Replacement of 2 No. windows & 1 No. door with PVCu Heritage Flush type to rear elevation. This application affects the character & appearance of the Littlehampton Seafront Conservation Area.

Second Floor Flat 37C South Terrace Littlehampton

Thank you for your internet representation made on 20th April 2020 which has been recorded as '**an objection**' with the comments as follows:

Proposed East Elevation of Rear Outrigger - 1/100

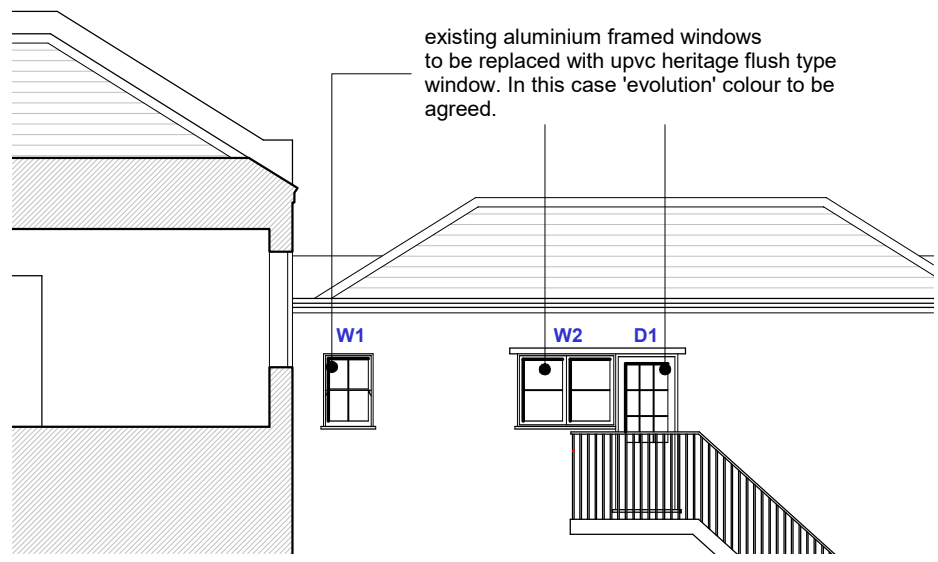
Use of PVCu within a Conservation Area should not be permitted however, more appropriate materials such as wood or powder-coated aluminium should be utilised.
